Engineers Comments Regarding Surface Water Drainage

Subject: Planning Consultation on: Y/7/22/PL

Application No: Y/7/22/PL

Site Address: Land adjacent to Bonhams & Flints Hoe Lane Flansham PO22 8NP

W1959-a - House II. - Floor Plans

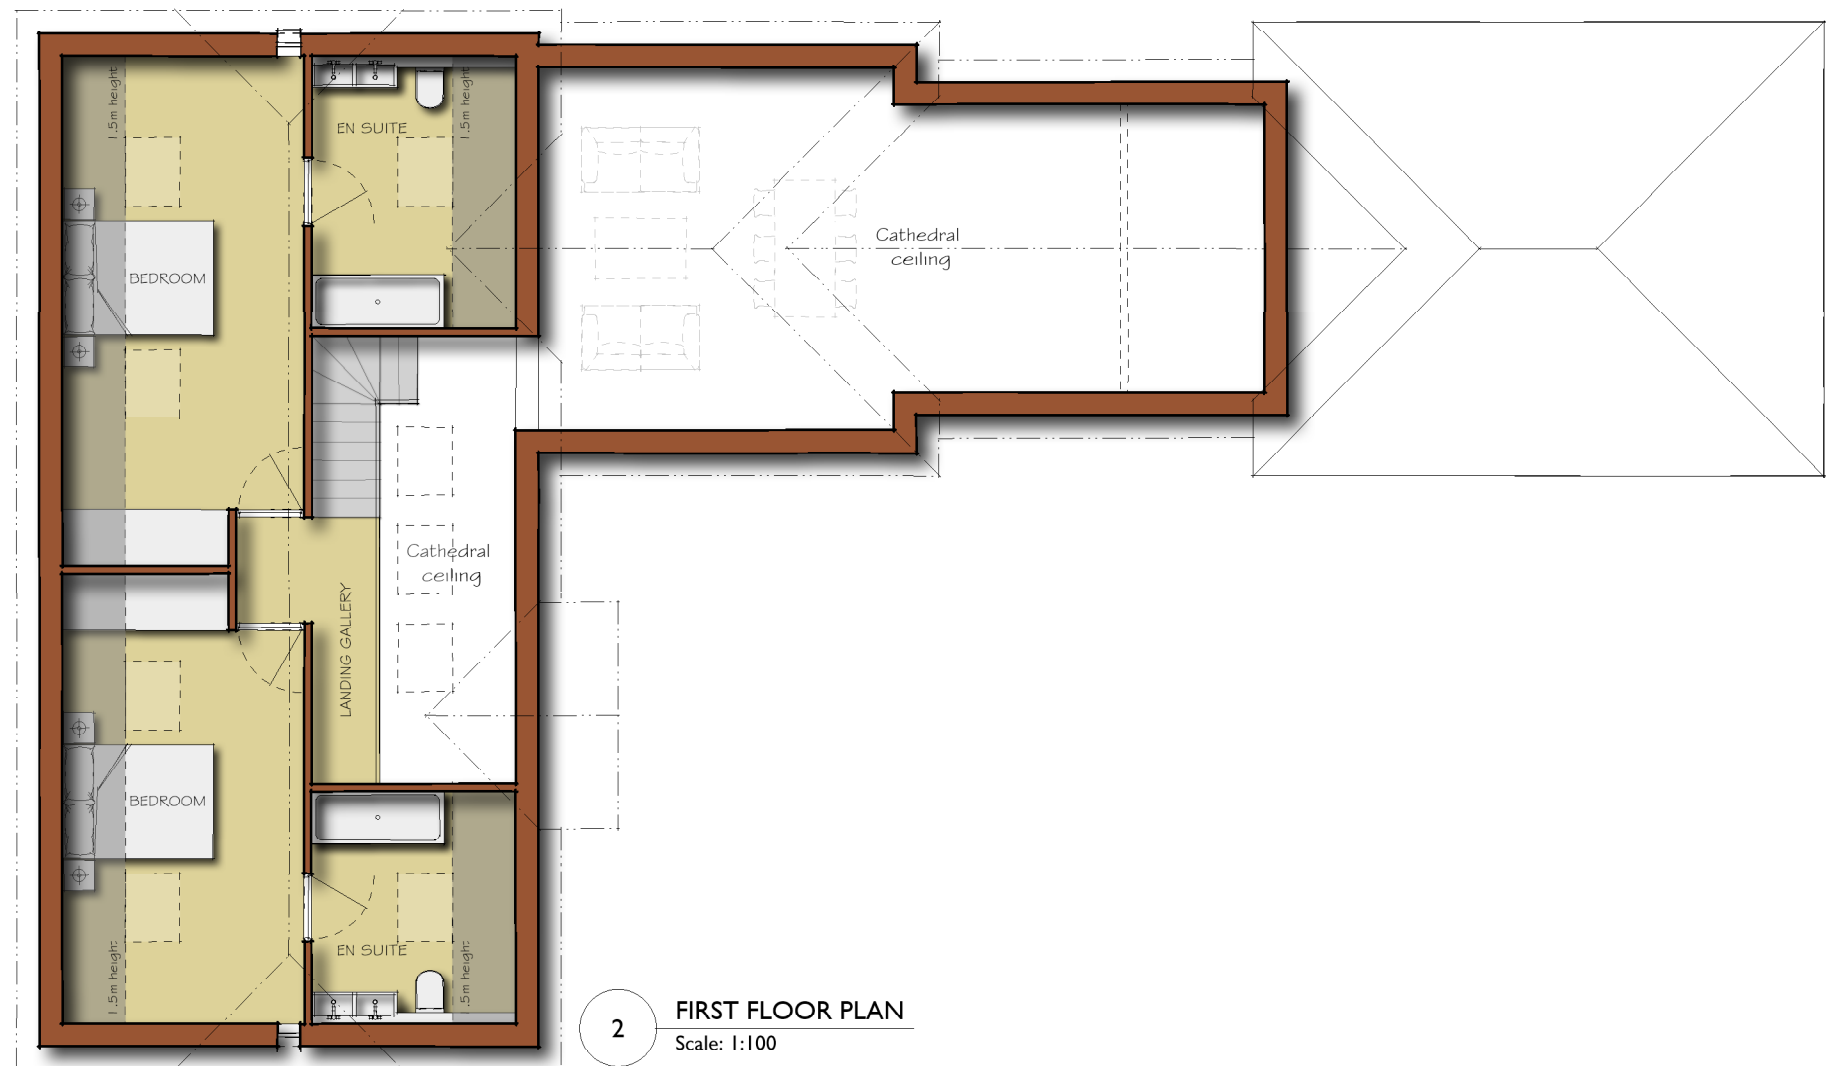
There is a foul rising main sewer running across the site and house 2 is proposed directly over the pipe. This is unlikely to be acceptable to Southern Water who will require strict easements and, if the layout is approved for the sewer to be diverted.
